Online Comment

Application H23-0864-25
Location Oak Lodge Saltney Gate Saracens Head PE12 8AT
Proposal Proposed New Dwelling including the demolition of existing domestic workshop

Name Diane Gordon
Address SHDC Environmental Protection

Proposed New Dwelling Oak Lodge, Saltney Gate Saracens Head, Holbeach For Mr M Hayes	Date November 2024	Drawn by RS Checked by
Sketch Scheme Plans, Sections and Elevations Site and Location Plans	Drawing Title Job No. SE-2213	Sheet Size A1 Dwg No. SS1000 Revision

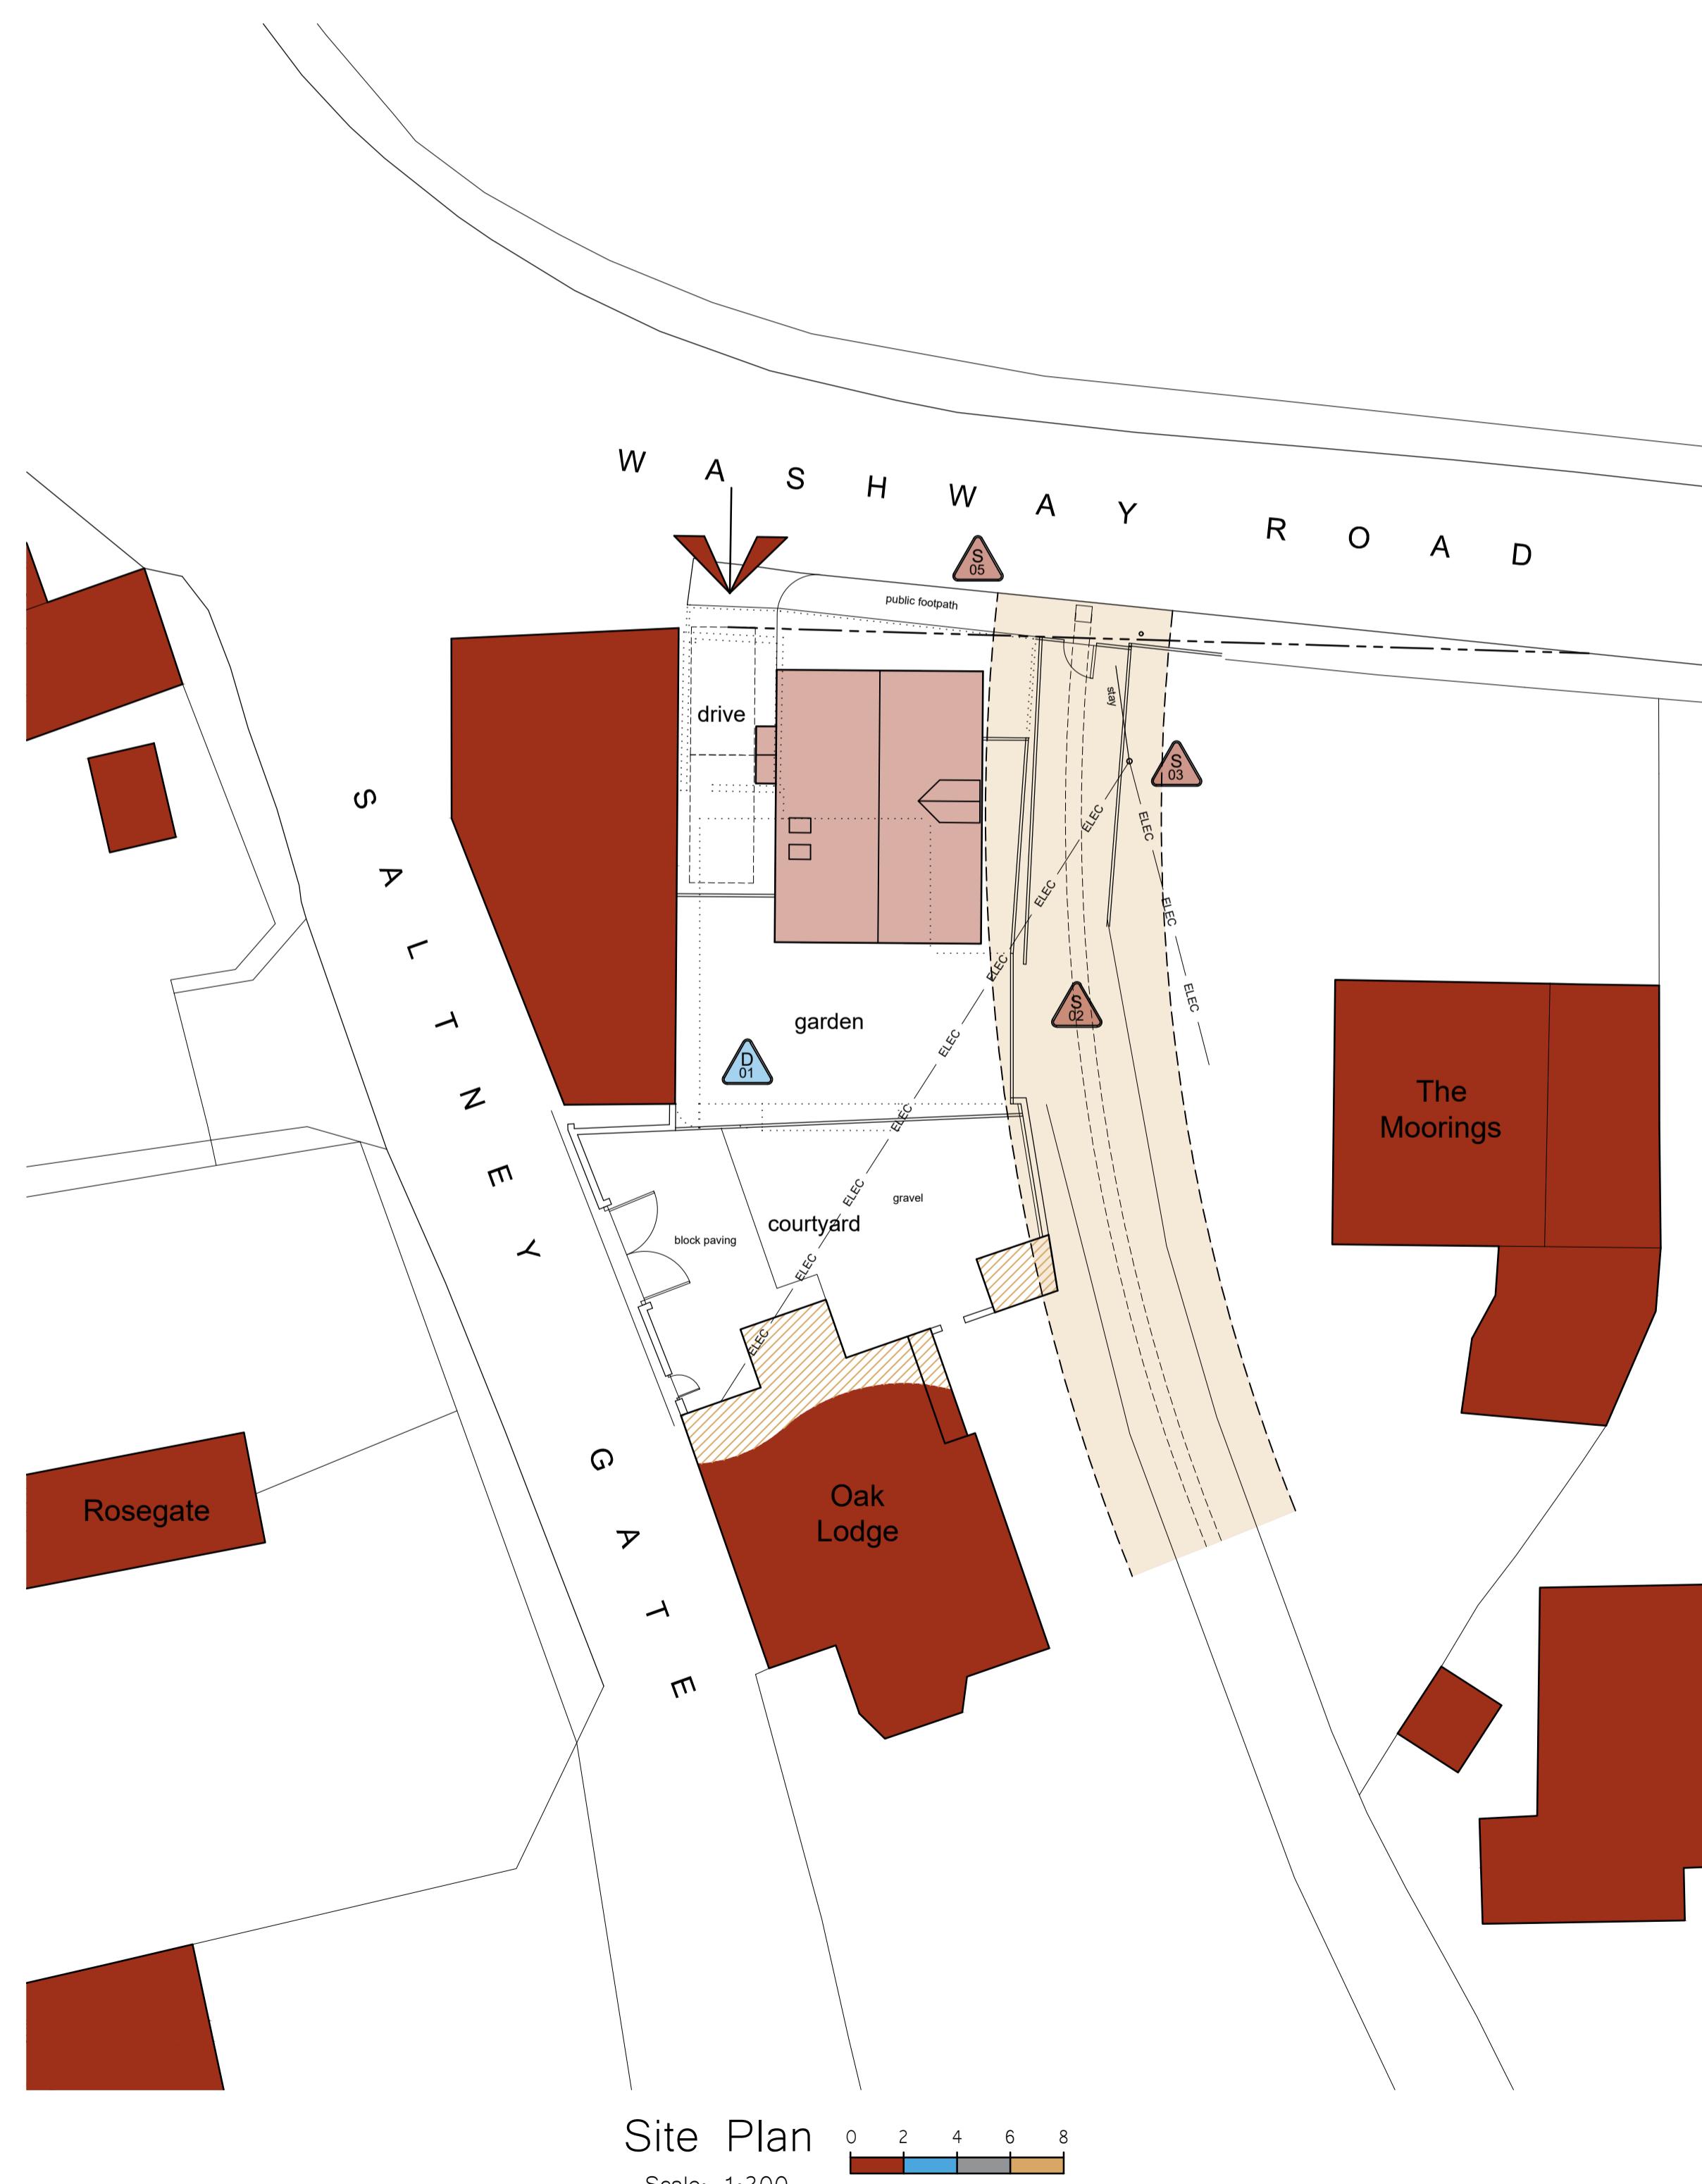
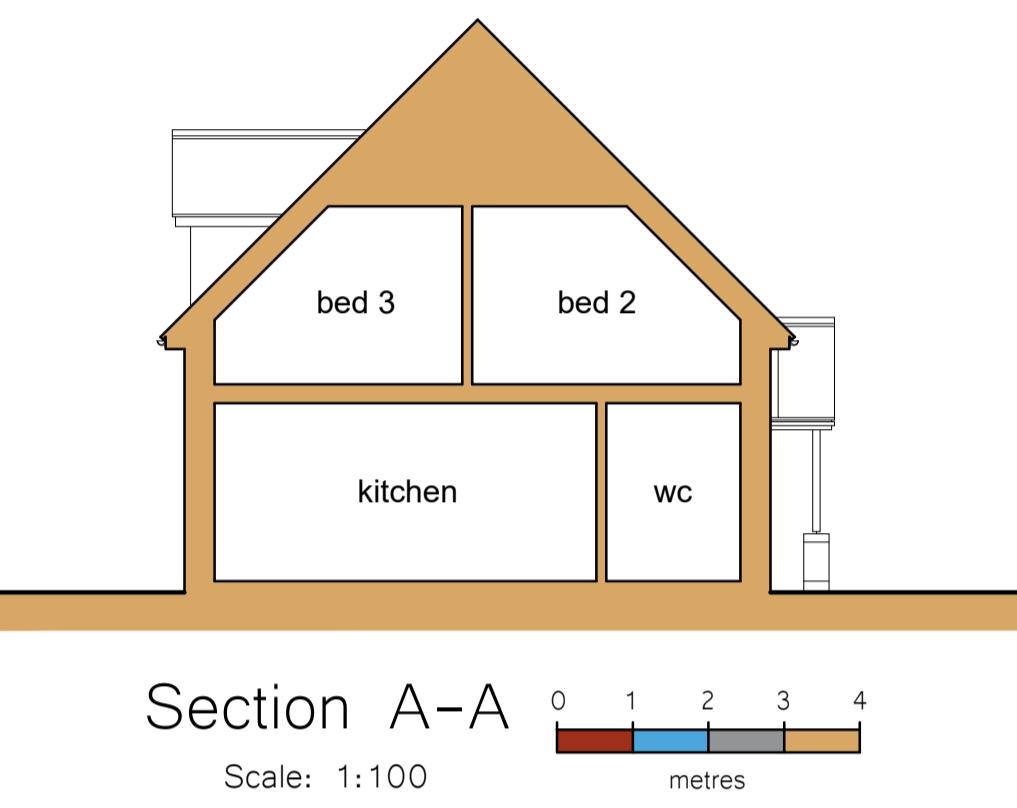
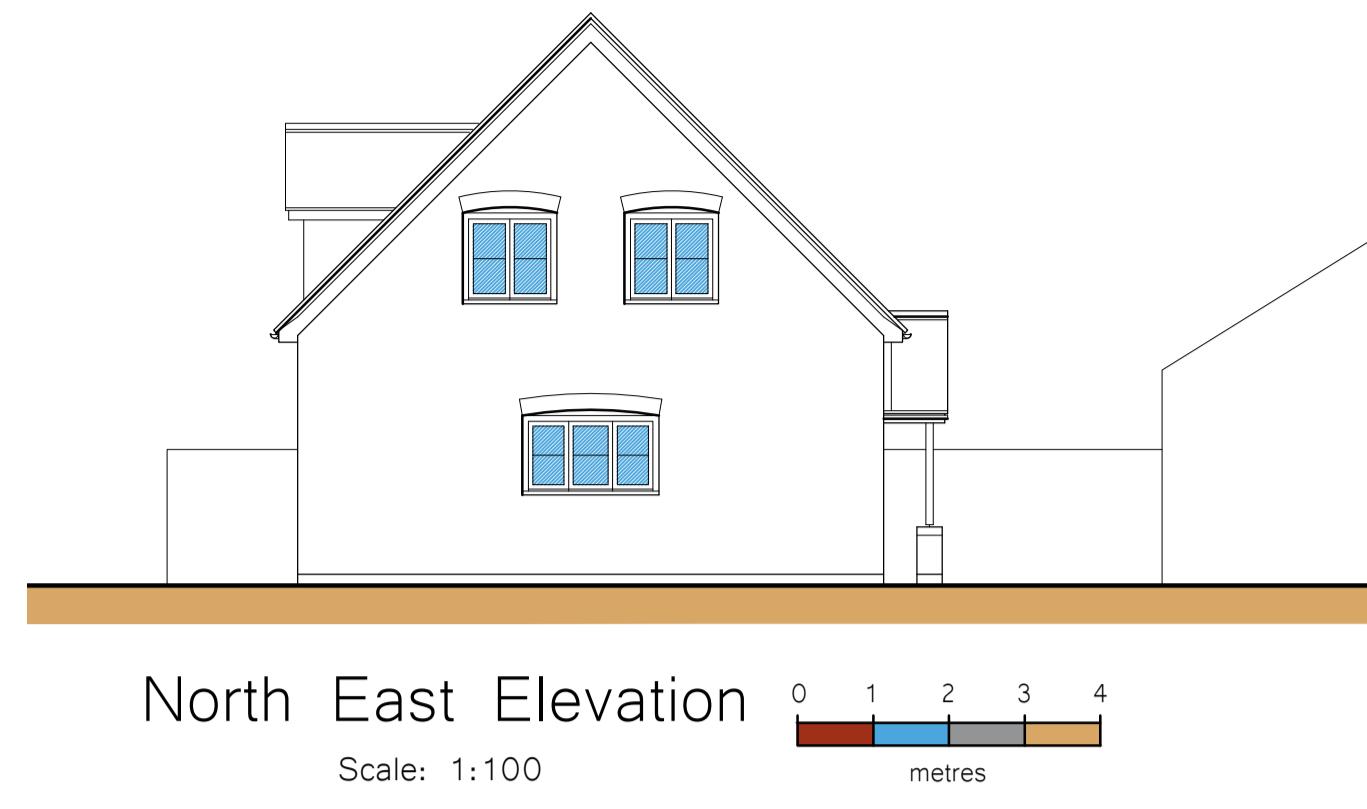
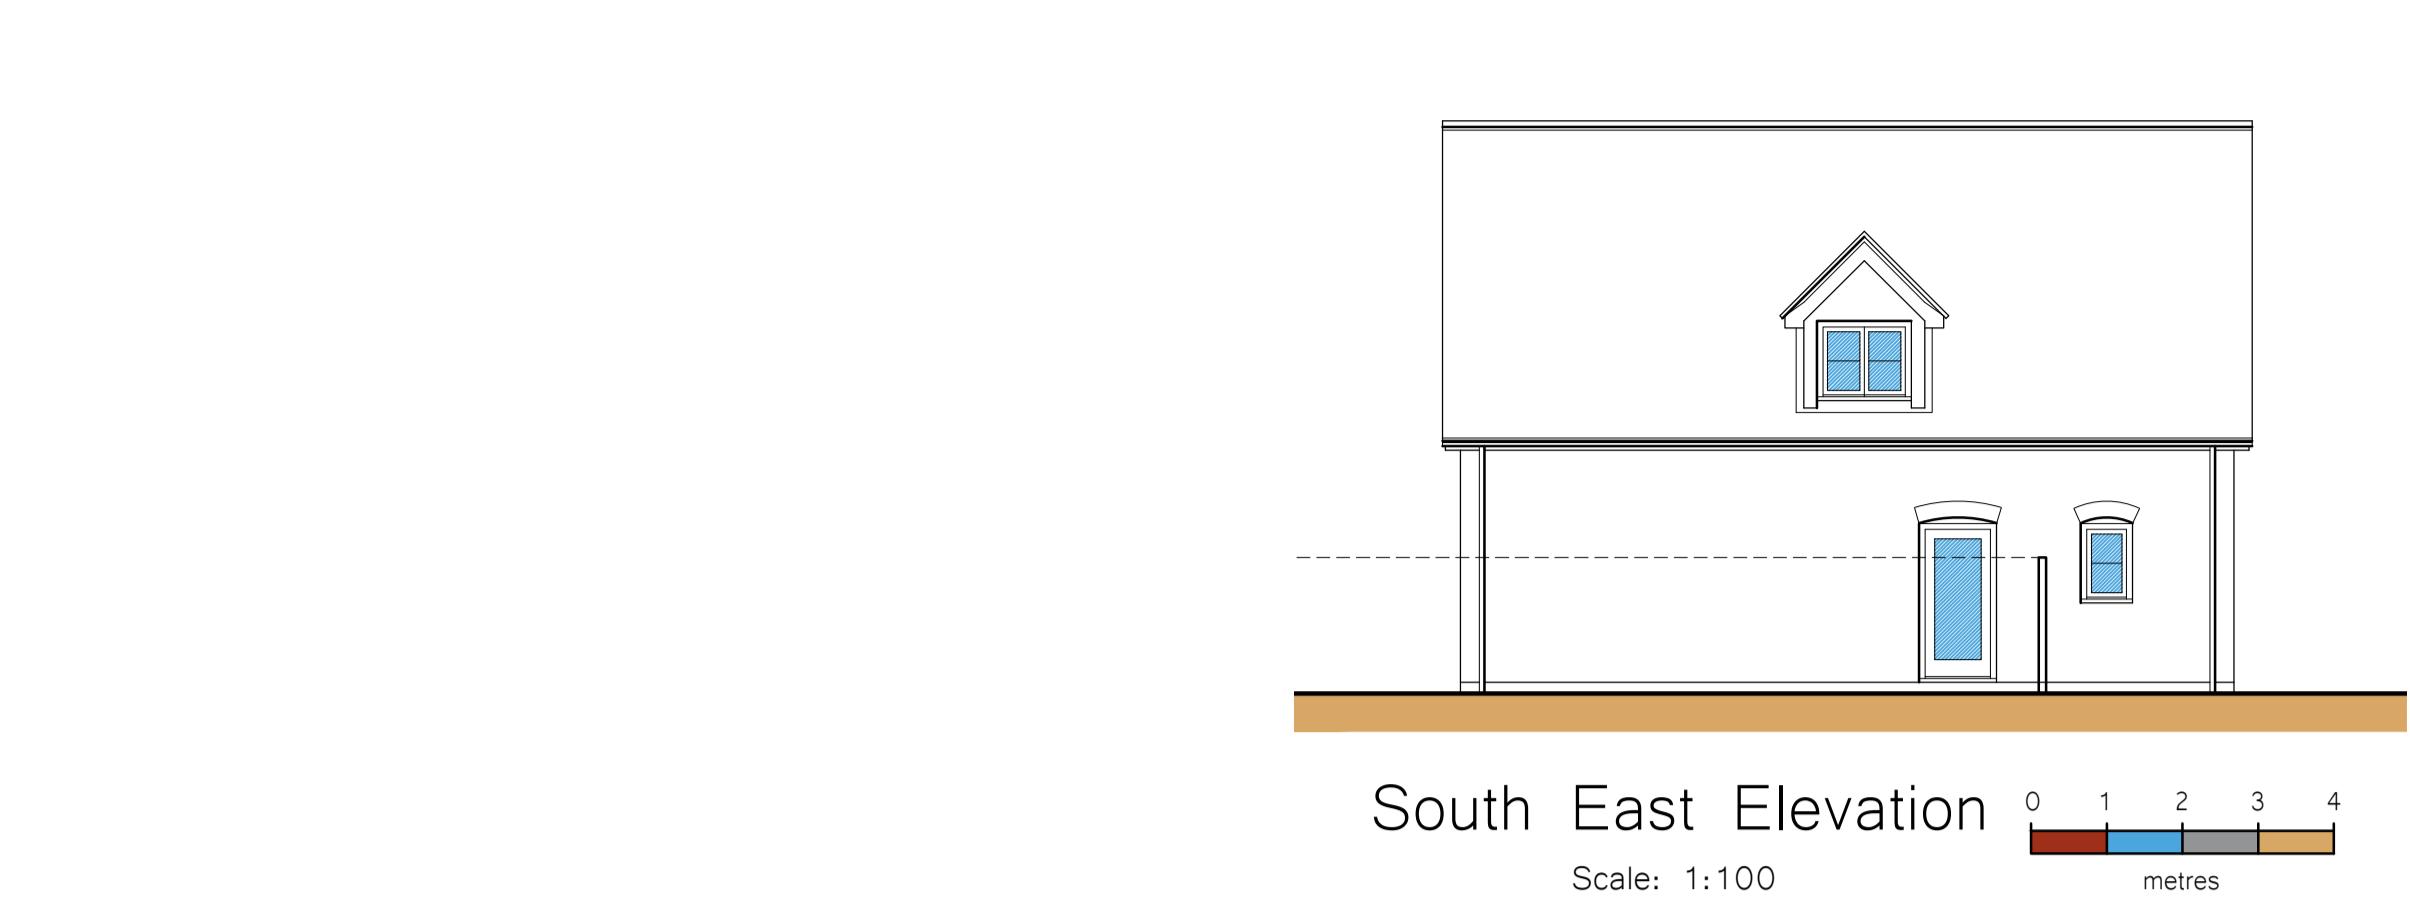
The proposal is adjacent to an established motor vehicle repair business and replaces a non domestic building. We would therefore recommend upgraded double glazing to the NW elevation bedroom to reduce any potential noise impact as this dwelling will be "agent of change" in this case
